Two storey side extension and single storey front extension, including alterations to external material cladding.

58 Roundstone Crescent East Preston

Thank you for your internet representation made on 24th July 2019 which has been recorded as '**an objection**' with the comments as follows:

Drawing  
**Proposed Drawings**

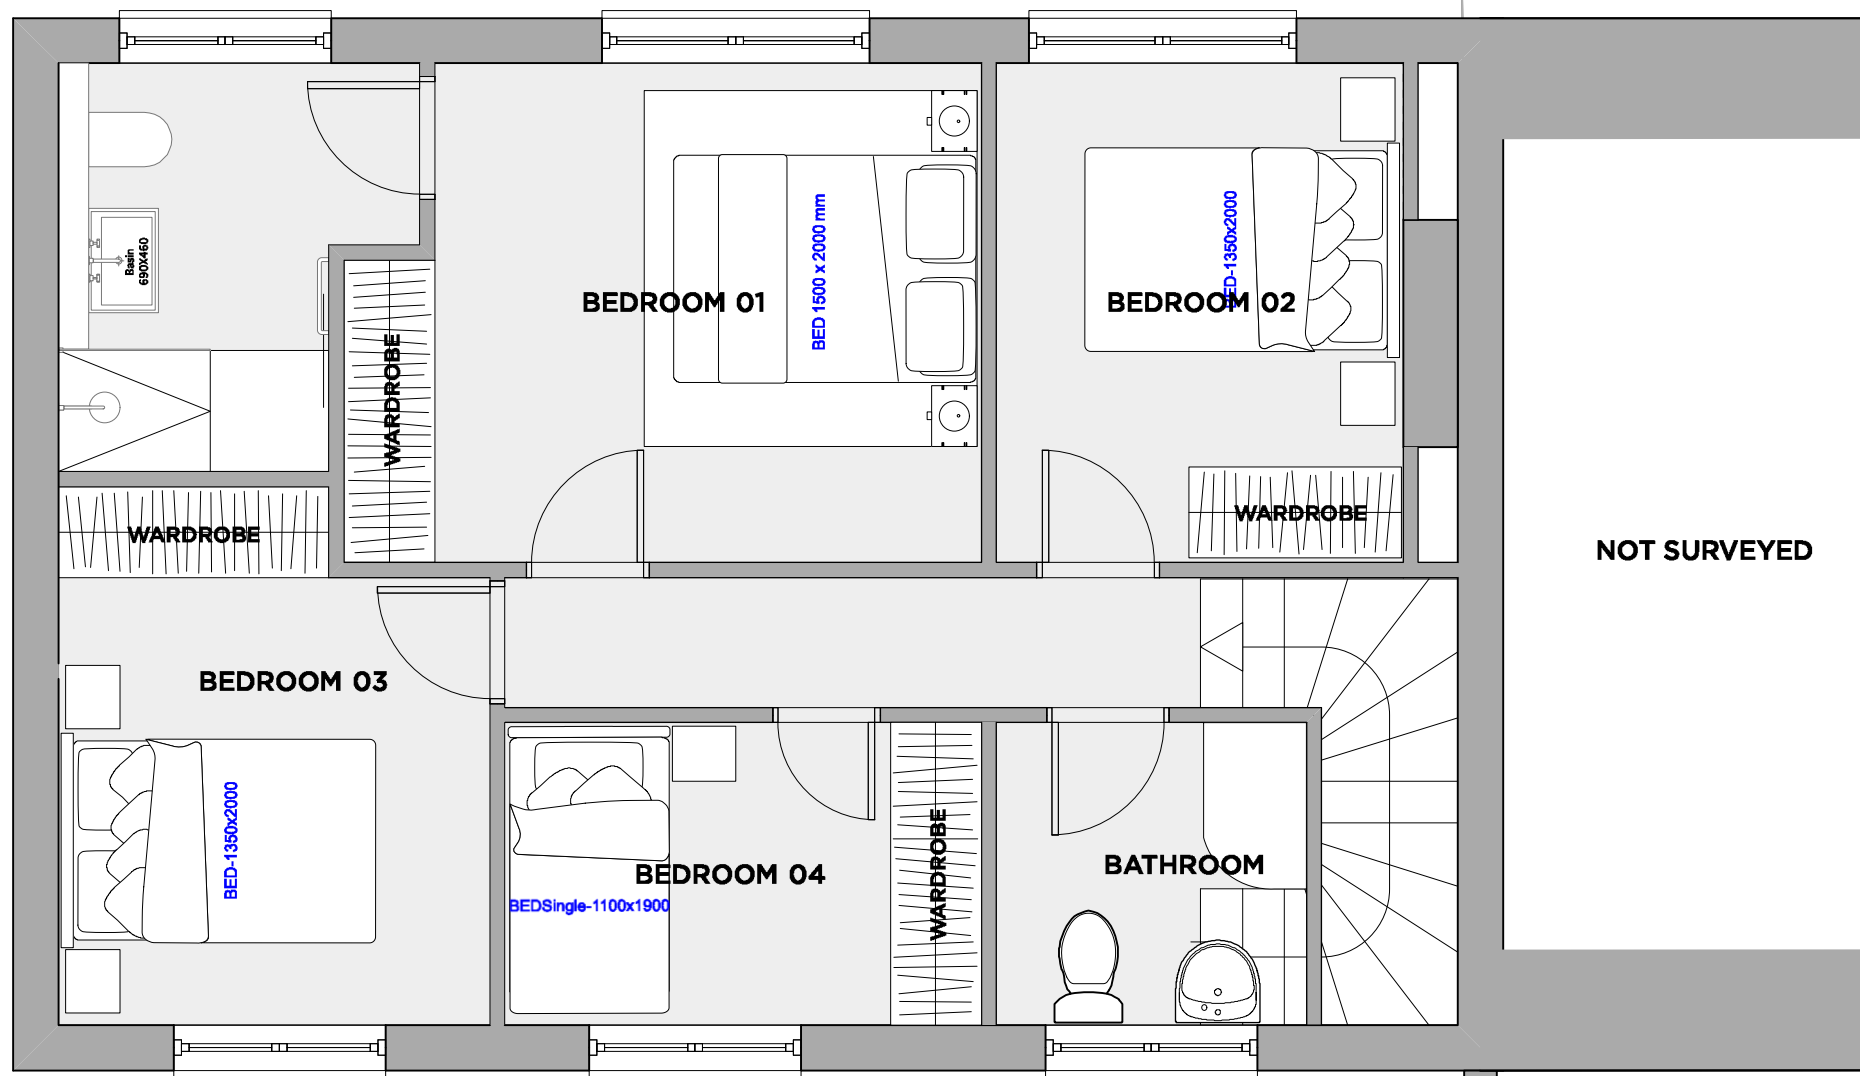
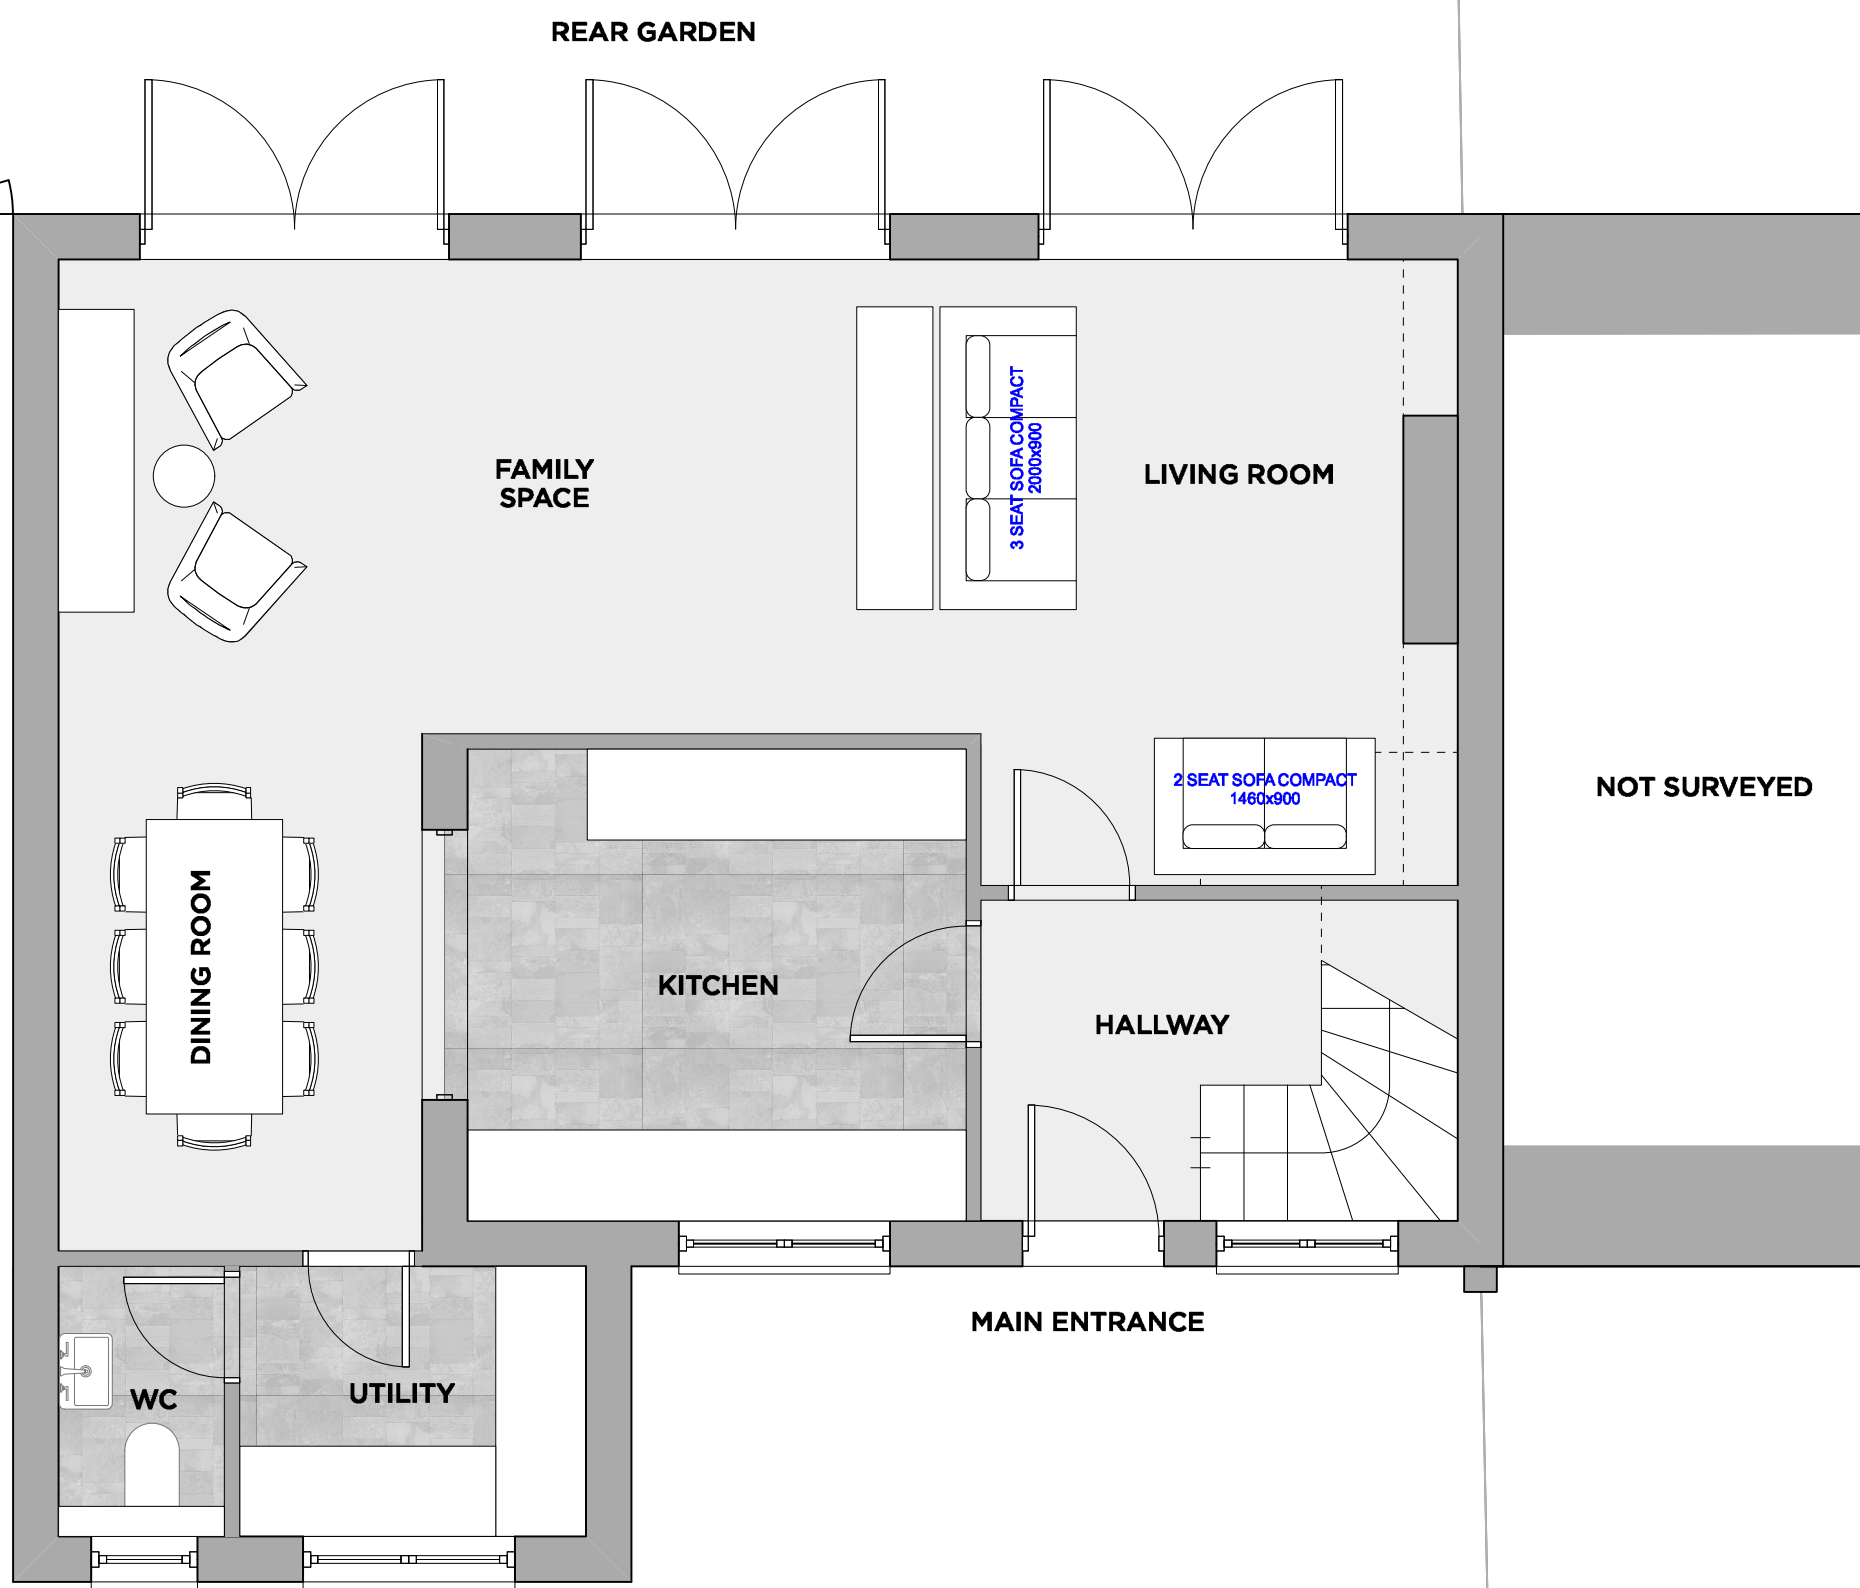
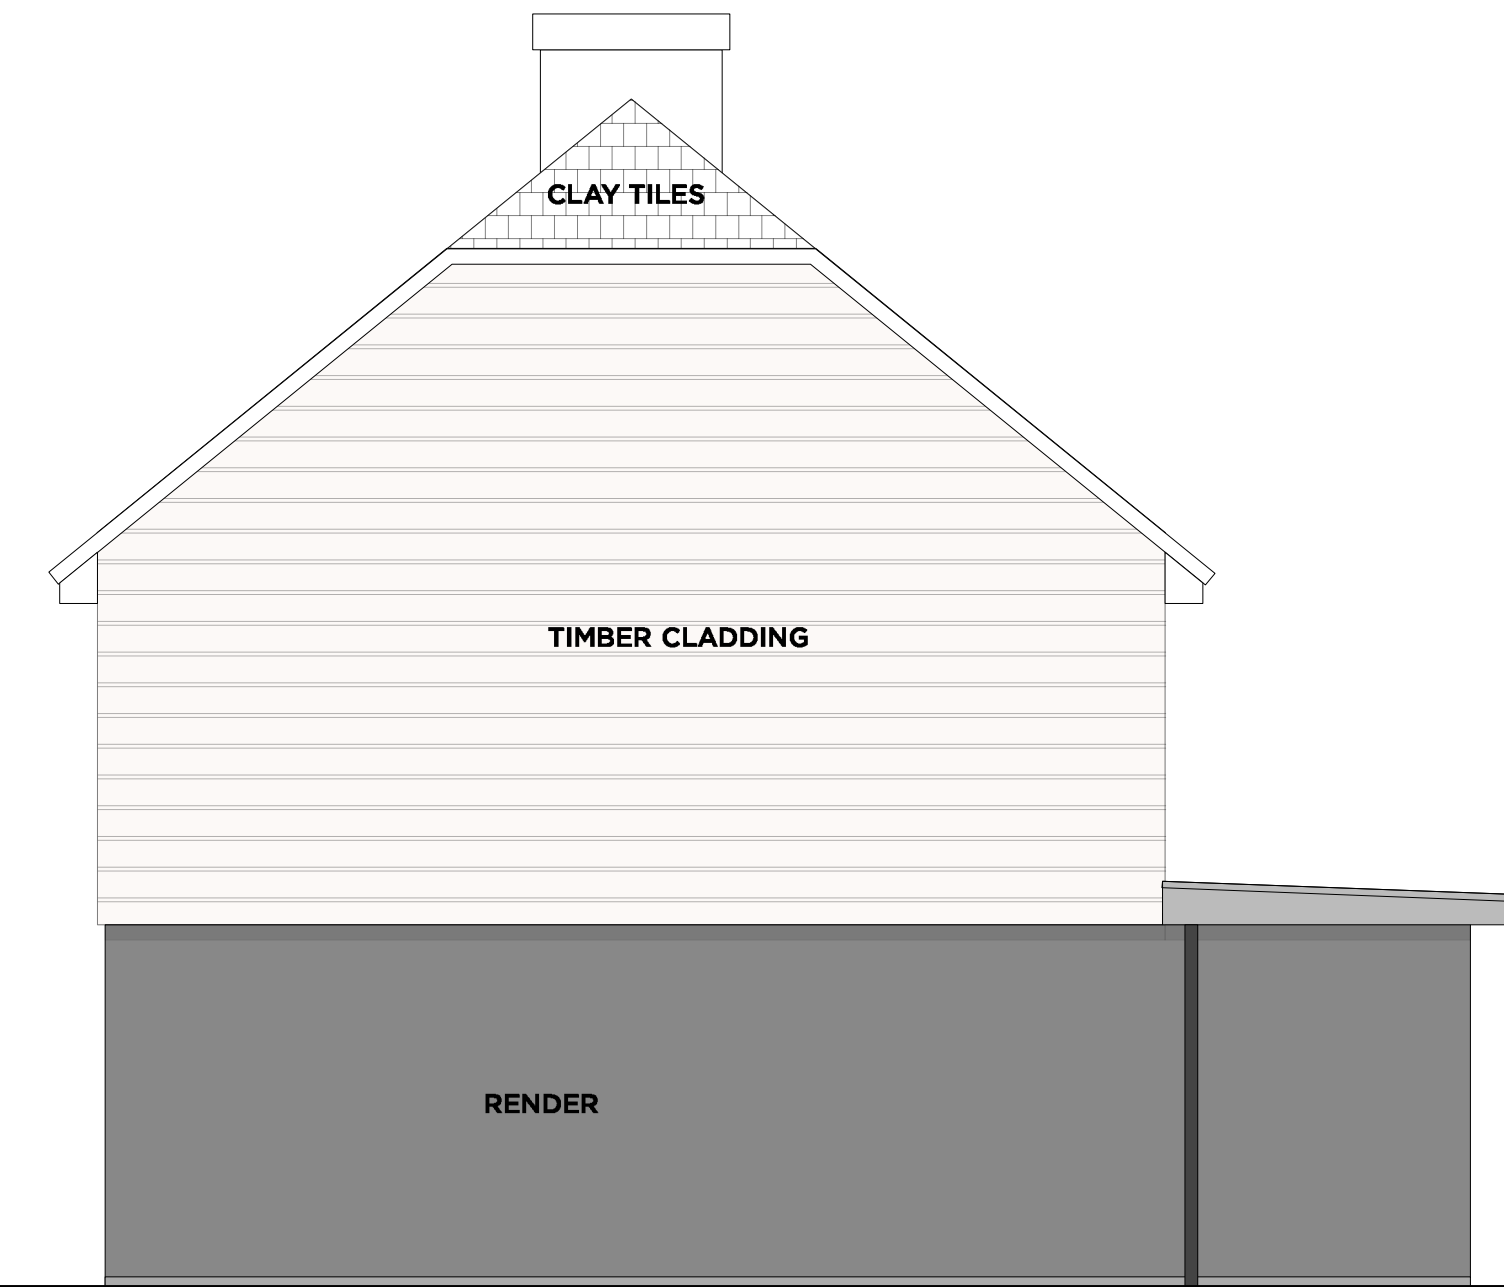
The Society does not object to the structural changes proposed in this application. It does, however, object to the proposed changes to the materials on the fa ade of the house. Covering the bricks on the lower half of the wall with dark grey render, and replacing the tiles on the upper half of the wall with timber cladding, would create a situation where the two halves of this pair of semi-detached houses had contrasting appearances on their facades. The differing materials would in no way blend, and the result would simply look a mess. This result would be contrary to policy D DM1 (1) of the Local Plan.

Permission for this change in materials should therefore be refused.
